Development Facilitation Team (DFT) – Review Comments

Project No: PR-2021-005714 Date: 09/27/2023 Agenda Item: #8 Zone Atlas Page: G-14

Location: 4000 2ND ST NW between HEADINGLY AVE and MESCALERO RD

Application For: SD-2023-00165-PRELIMINARY/FINAL PLAT (DHO)

DISCOUNT TOWING HEADINGLY AVE.	DRAWN BY DEM
	GRADING AND DRAINAGE PLAN	DATE 10-10-22
	SHEET # C1	DISCOUNT TOWING DWG
DAVID SOULE P.E. #14522	RIO BOX 53204 ALBUQUERQUE, NM 87199 (505) 321-8099	JOB #

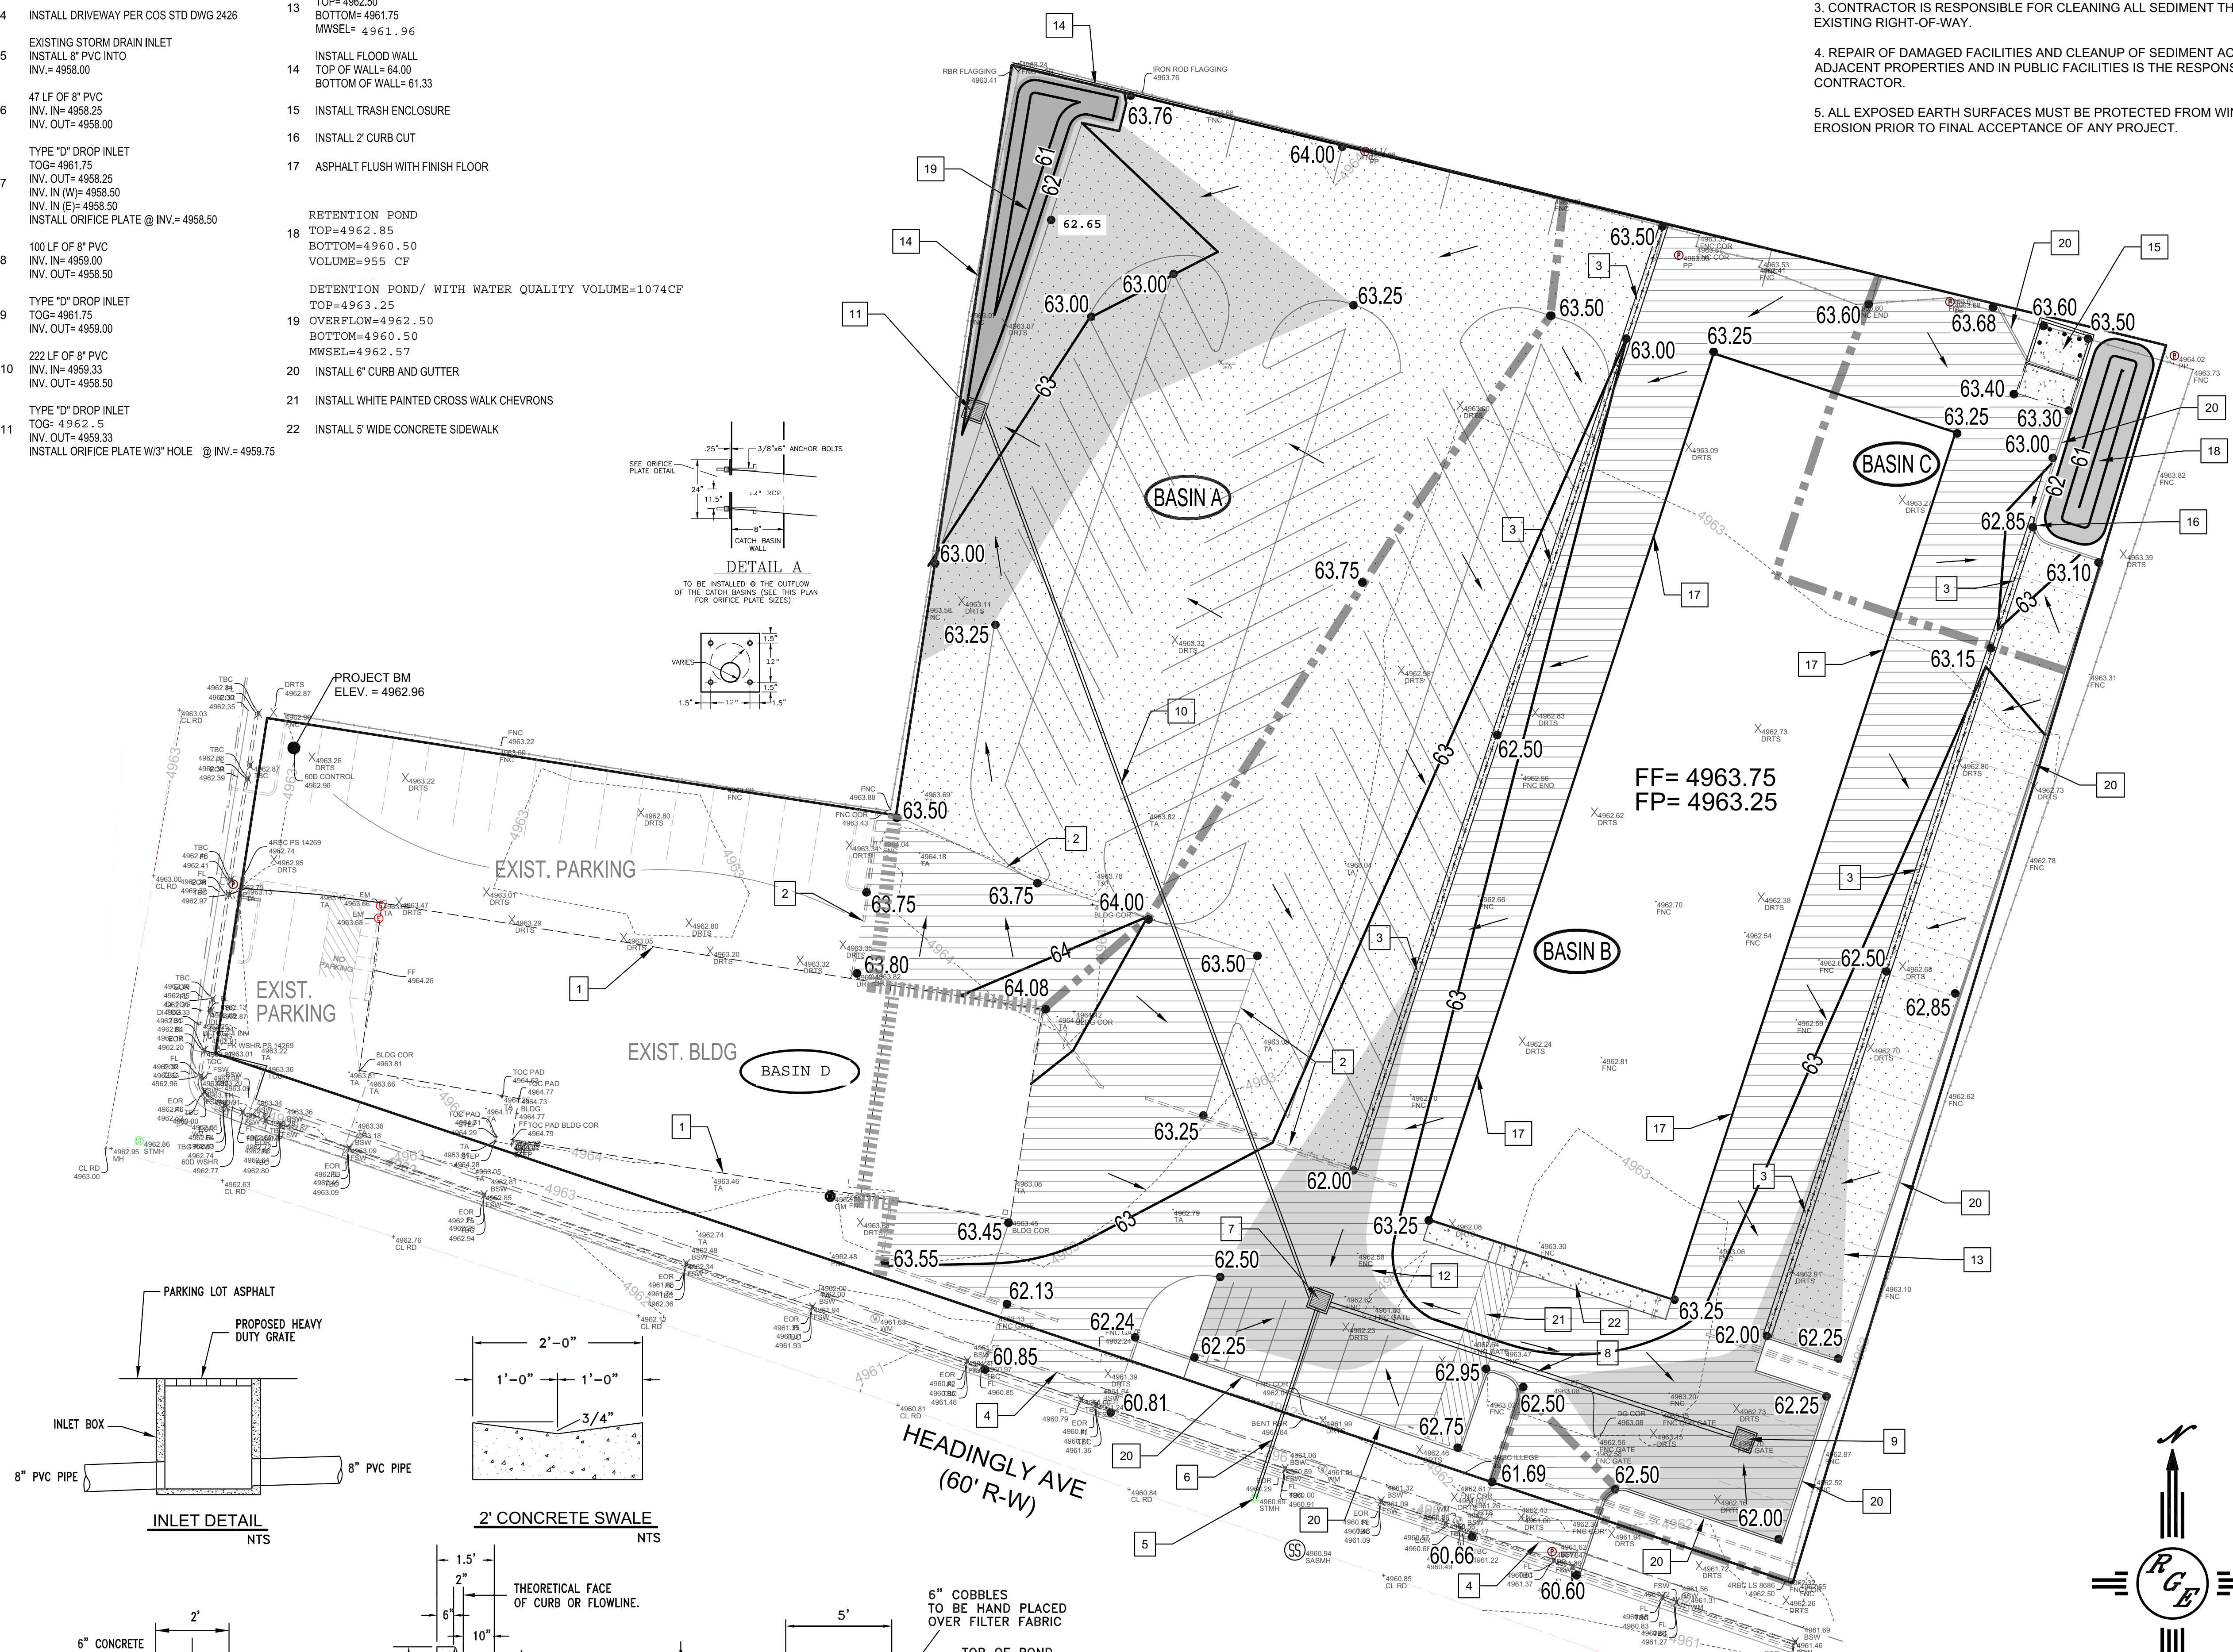
- Hydrology has an approved Grading & Drainage Plan (G14D100) with engineer's stamp 12/02/2022.
- Hydrology has no objection to the platting action.

PLAT
OF
LOTS 1-A
MONKBRIDGE ADDITION
PROJECTED SECTION 5 T10N, R3E, N.M.P.M.
WITHIN THE TOWN OF ALBUQUERQUE GRANT
ALBUQUERQUE, BERNALILLO COUNTY, NEW MEXICO
JUNE 2021

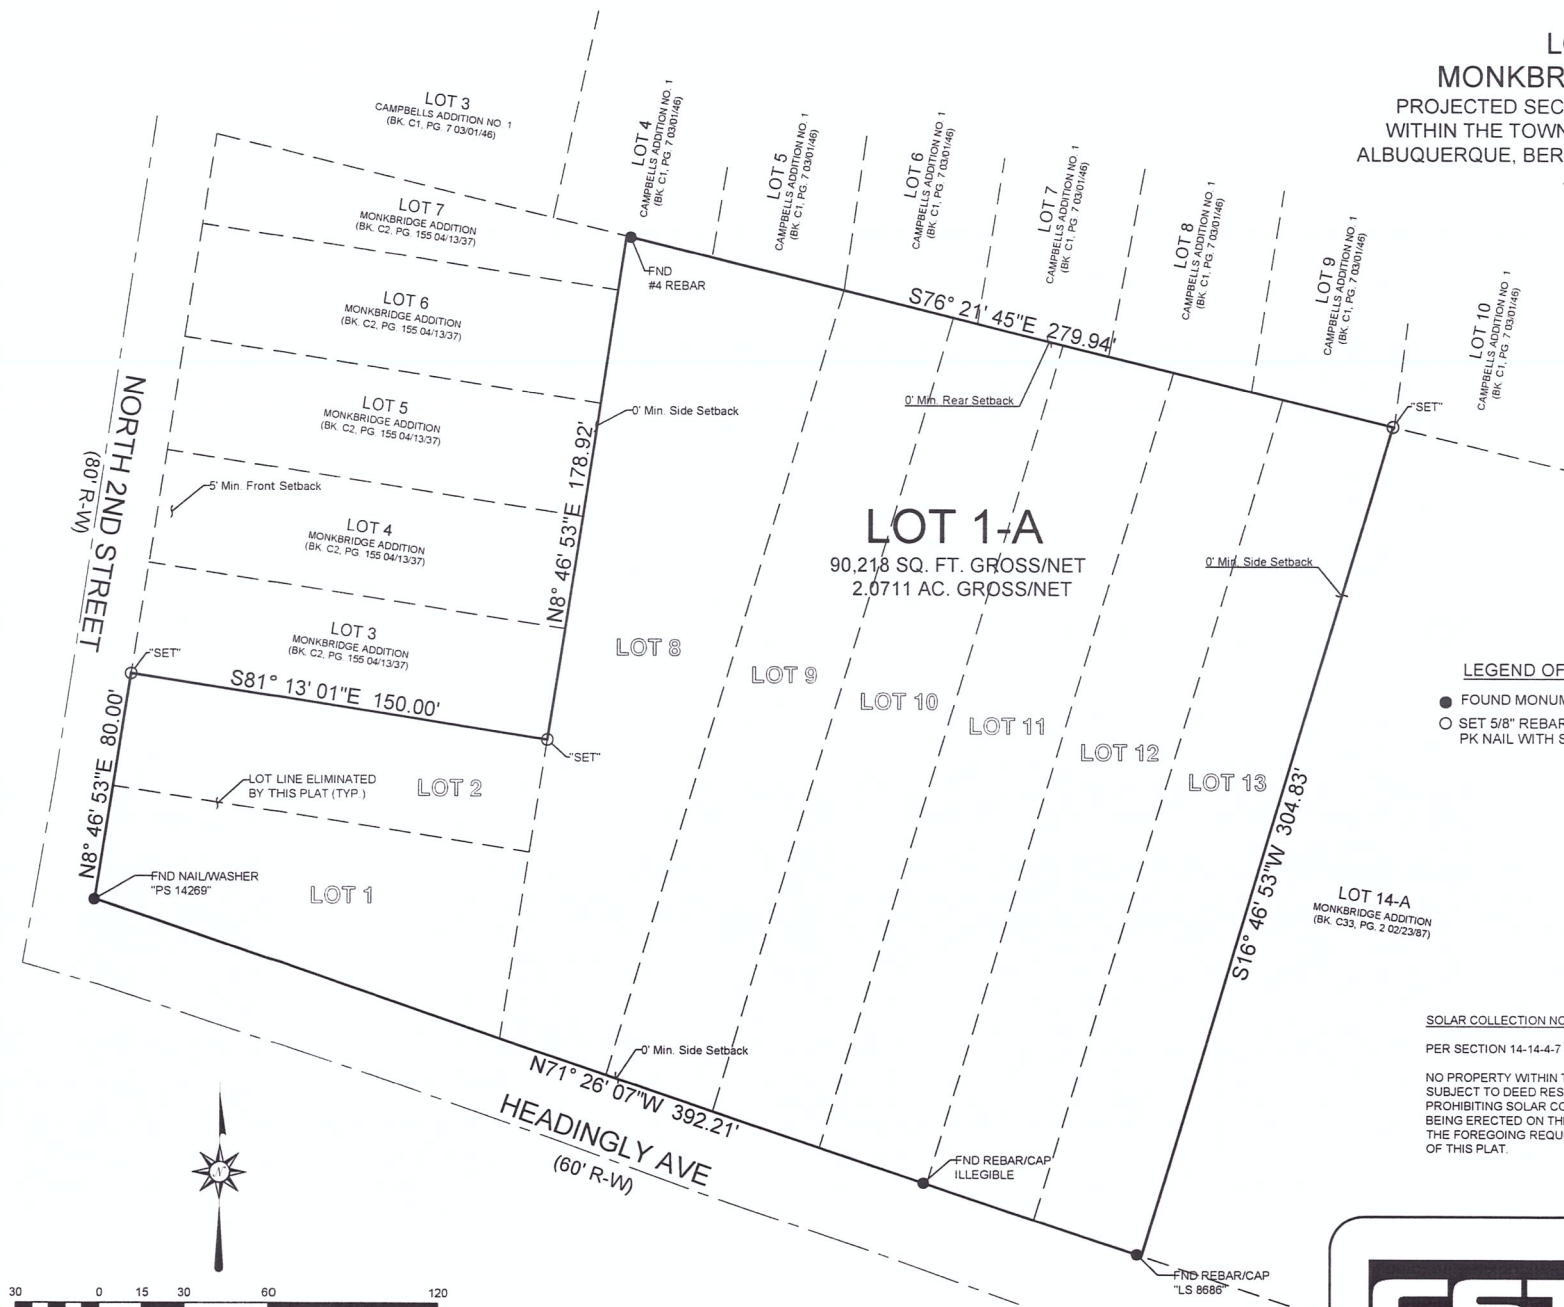
1. Preliminary plat:
 - a. Add the following note to the plat.
 - i. “Existing public water and/or sanitary sewer infrastructure may not be constructed or sized to adequately serve potential future development. Improvement or upsizing of existing public infrastructure may be required as a condition of future development approval.”
 - b. No issues with the proposed lot consolidation.
 - i. Availability Letter 230411 has been issued and identifies the conditions for service. Fire flow cannot be met with existing conditions and line upsizing is required. Construction or infrastructure list guarantee to install new fire hydrant and installation of new 8” main for the proposed development.
